Your ref: P/95/21/PL

20 July 2021

Retention of 4 mobile homes for countryside workers together with drainage and service connection provision in connection with permission P/72/09 as varied by P/22/017/PL (resubmission following P/86/20/PL). This site is in CIL Zone 5 (Zero Rated) as other development. Bowley Farm Bowley Lane South Mundham Chichester PO21 1NB

SITE PLAN
1:500 @ A2

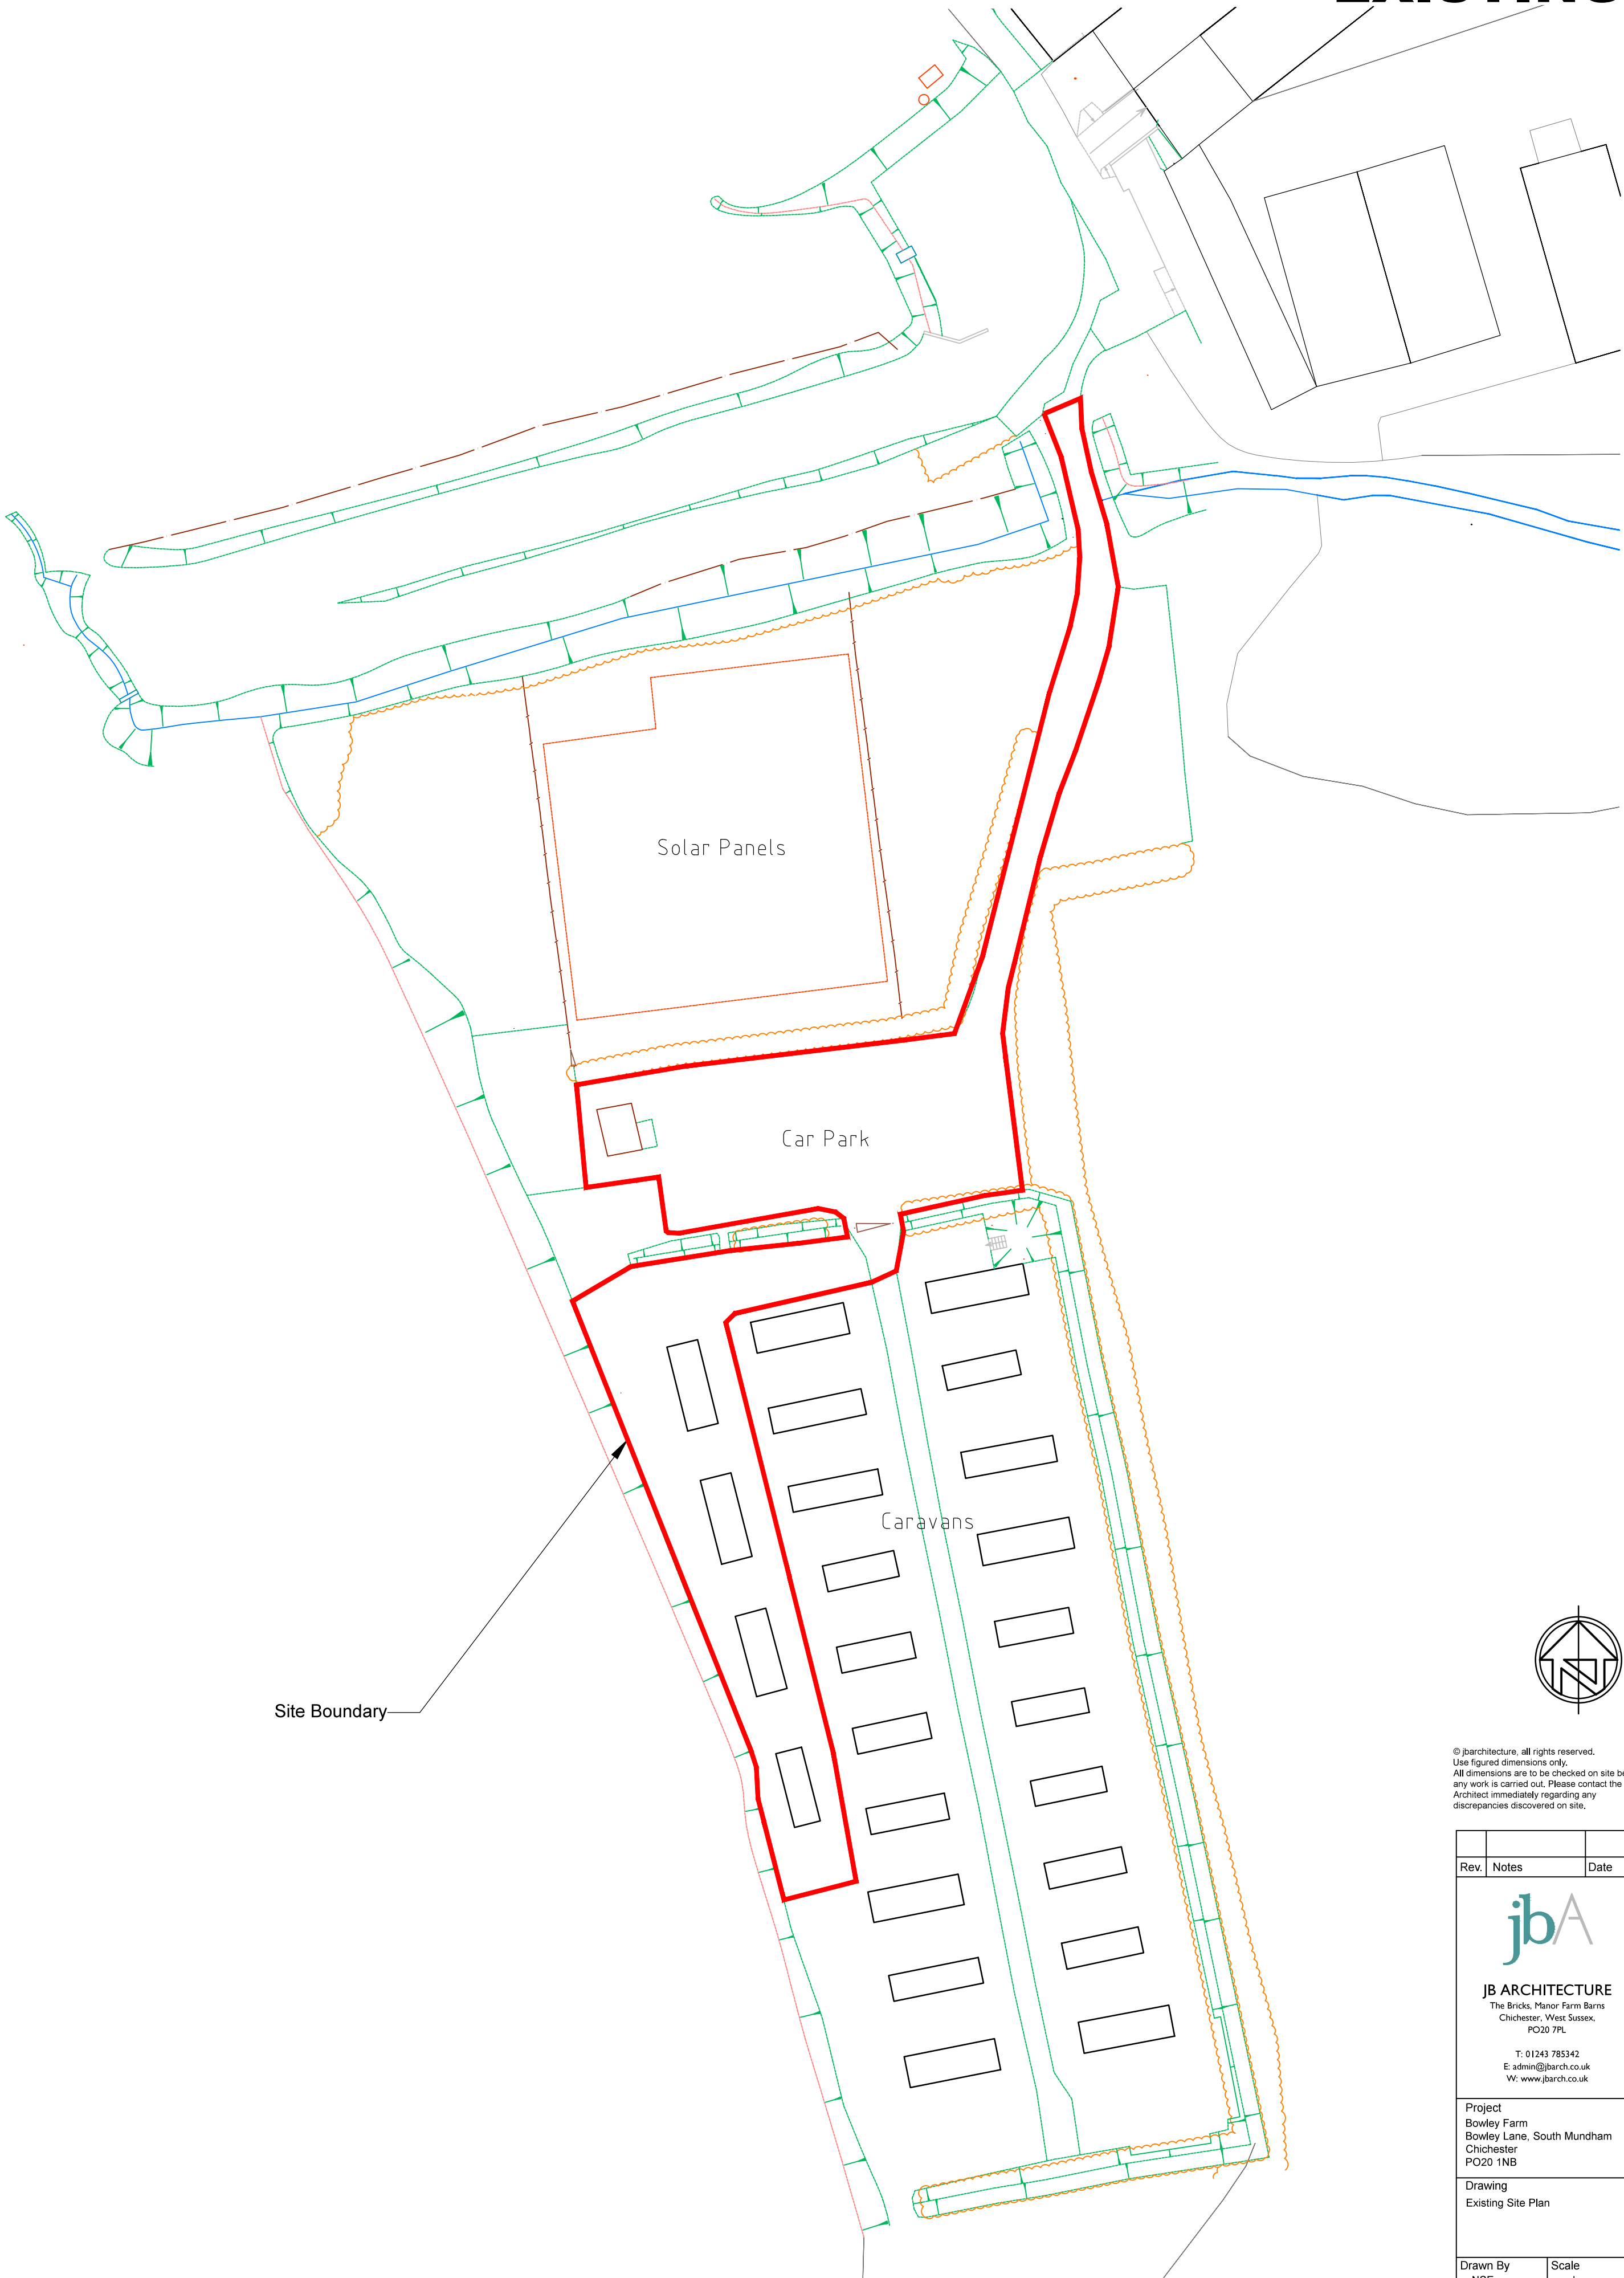
The application cover letter, site plan and location plan do not accurately reflect the number of mobile homes that are present on the site. In particular, the application suggests that the 4 mobile homes for which retrospective planning permission is sought and the 20 mobile homes granted conditional planning permission in January 2010 (P/72/09) are the only mobile homes present on site. This is inaccurate. It is understood that there are in fact 54 mobile homes

present on the site.¹ Of these structures, 34 do not have planning permission. The existence of these other mobile homes is relevant to the planning permission in question because of their cumulative impact, including on highway safety, fire safety, foul water infrastructure, and the fact that this application is likely to act as a precedent for future applications. The failure to disclose the existence of these other developments has undermined the ability of consultees to properly consider the impact of this application.
